March 14, 2006

RE: Application for Lot #18, Oak Ridge Subdivision, Ruby Lane

Upon review of the site plan, the City's Planning Division has the following comments:

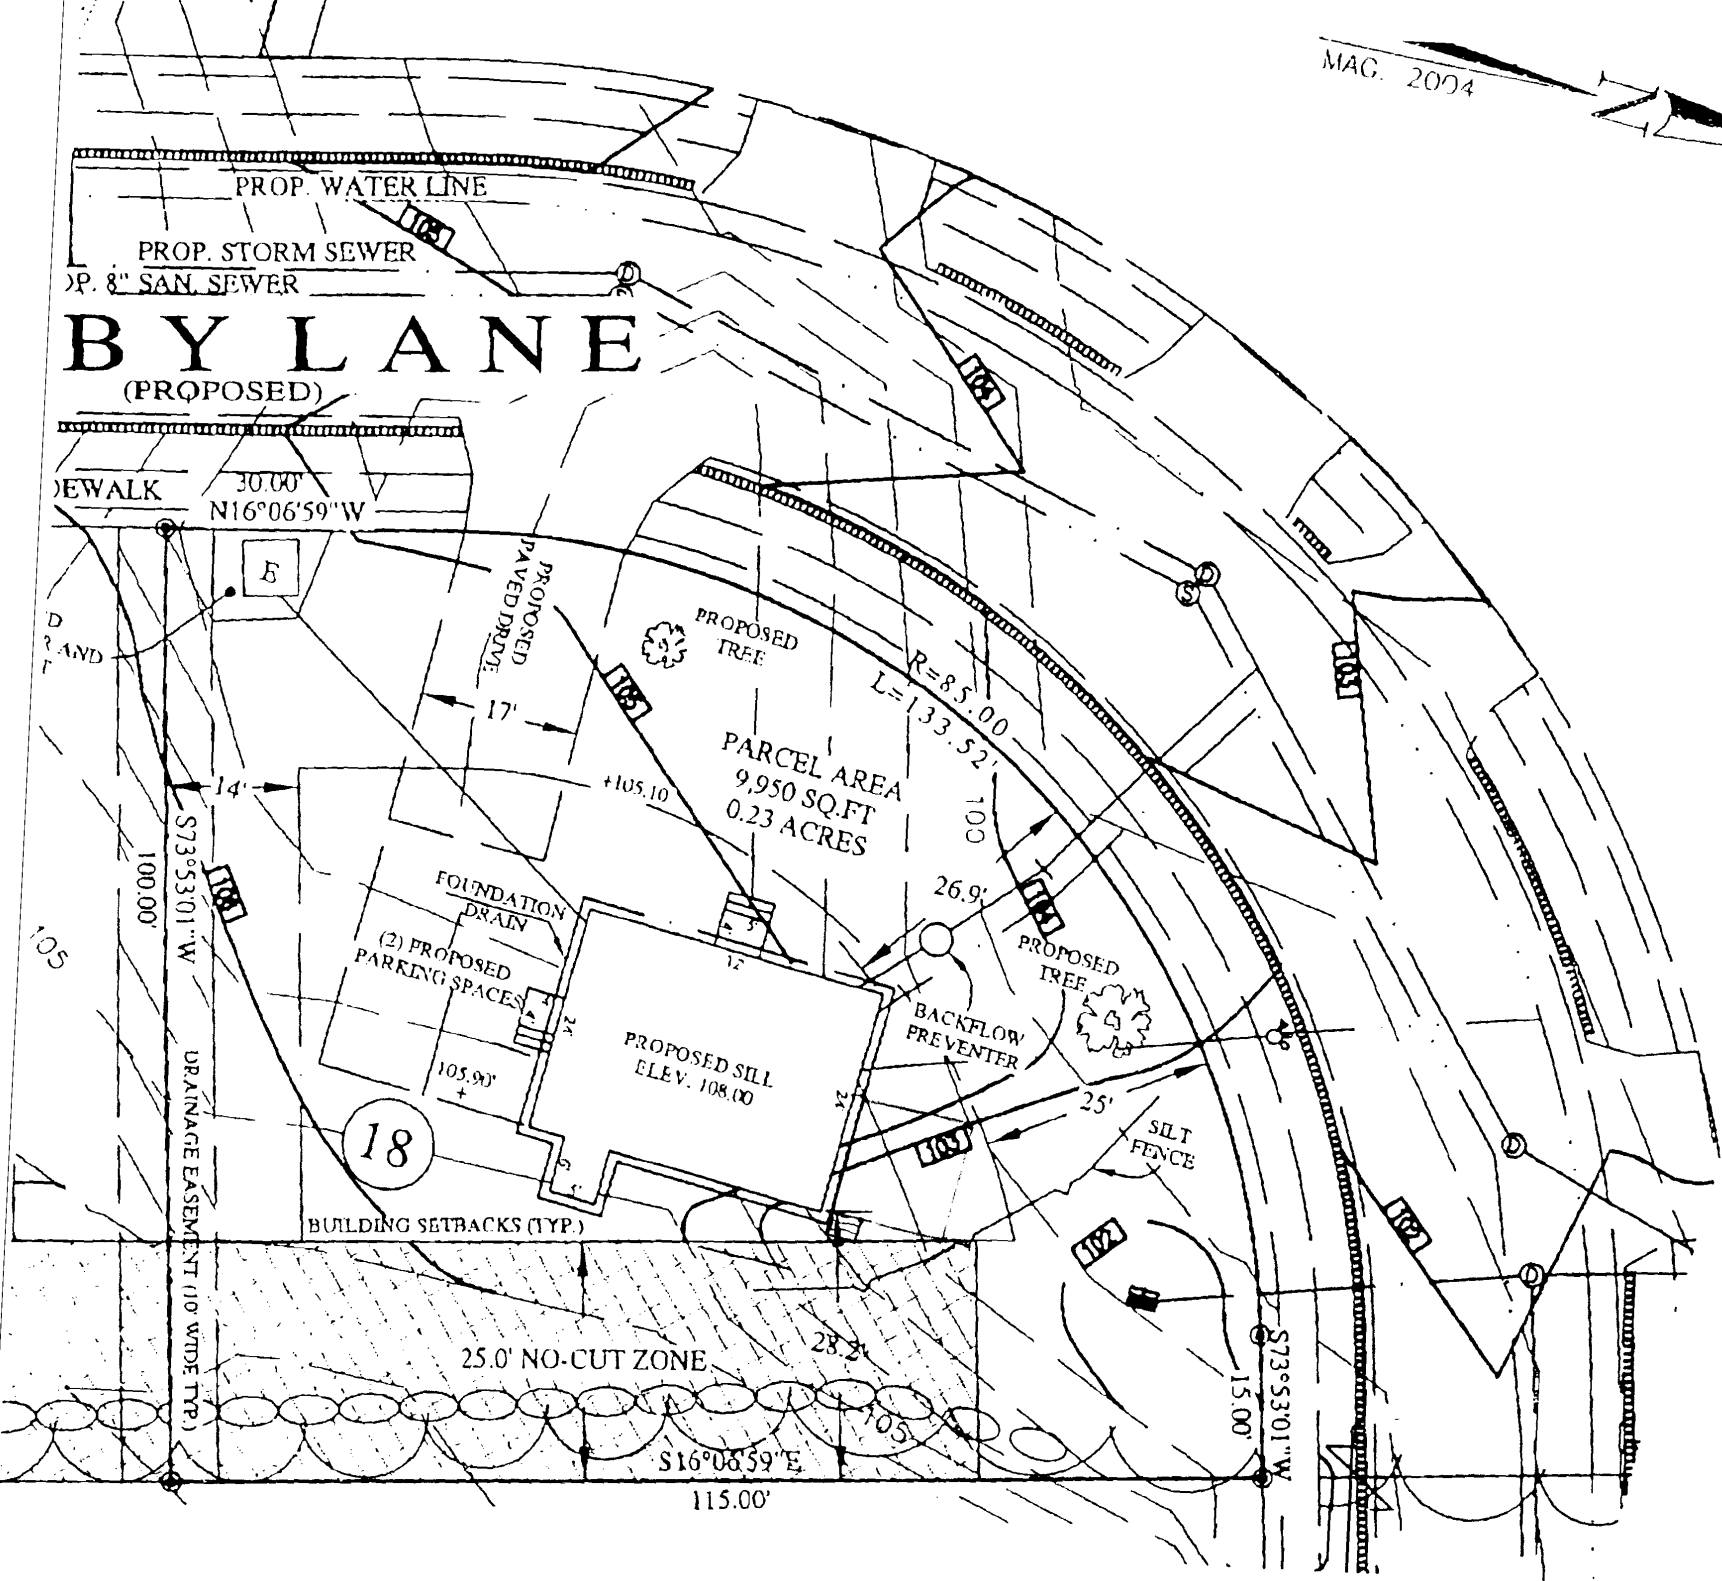
1. Please add erosion control/silt fence to the site plan in the vicinity of the catch basin.
2. Please add a backflow preventer to the storm drain line (required).
3. Please label the two existing trees shown as 'to be preserved/saved'.
4. Please add 2 street trees (required for single family development, to be installed along the street frontage of the property) to your site plan.
